Date 7 March 2024
Our Ref 24/00227/FLH

Town and Country Planning Act 1990 (As Amended)
494 Chessington Road, West Ewell, Surrey
Conversion of garage to accommodate a habitable space

**Block Plan for
494 Chessington Road, Epsom KT19 9HF**

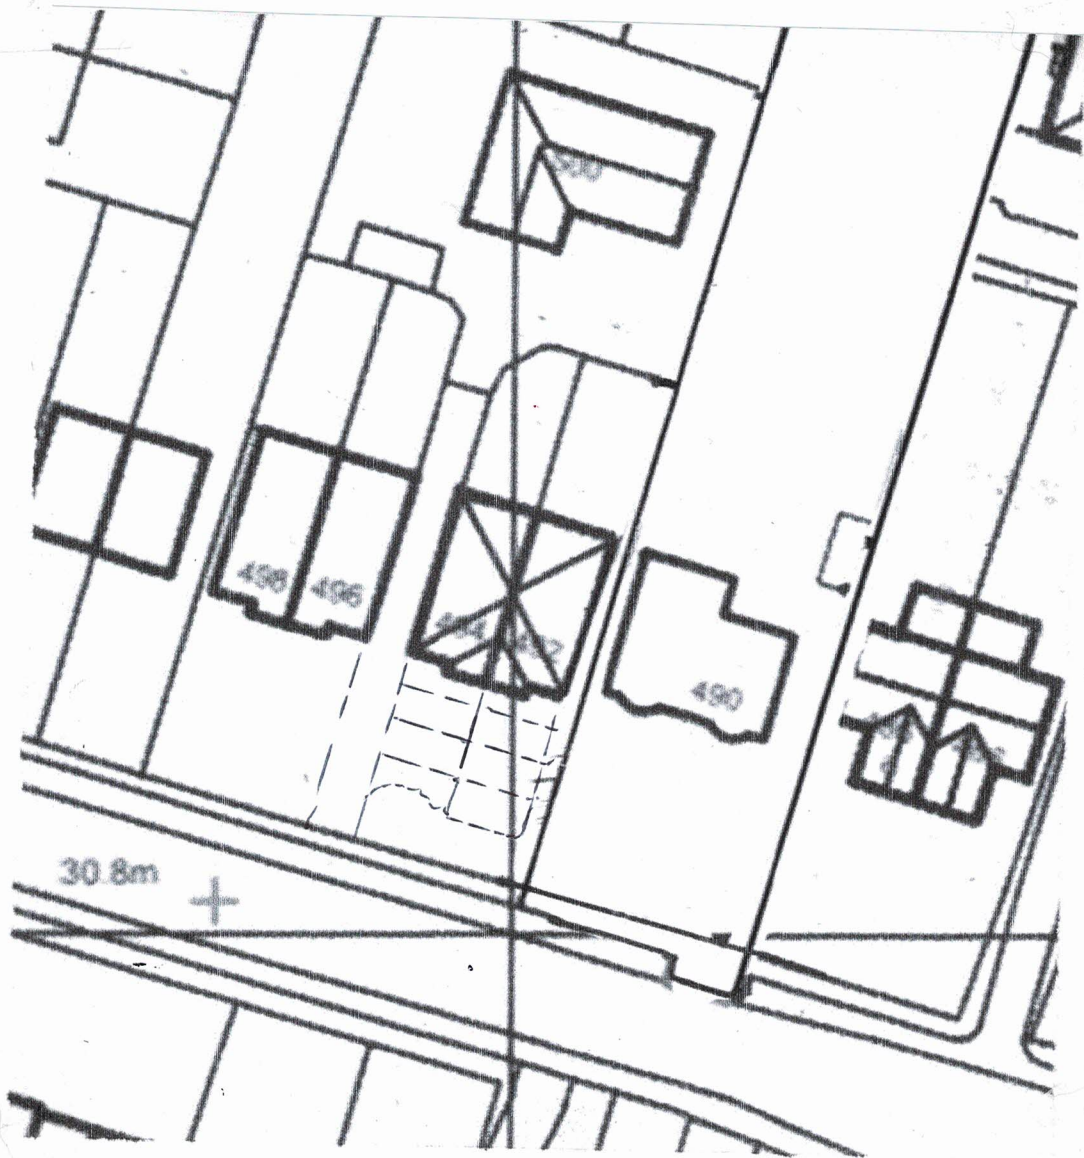
1 LOCATION PLAN - There is no red line that outlines and clearly highlights the site address. The application requires the submission of a location plan, usually at a scale of 1:1250, which must identify sufficient roads and/or buildings on land adjoining the application site, to ensure that the exact location of the application site is clear. The application site should be edged clearly with a red line on the location plan and should include all land necessary to carry out the proposed development which includes land required for access to the site from a public highway. The plan should also show the direction of North.
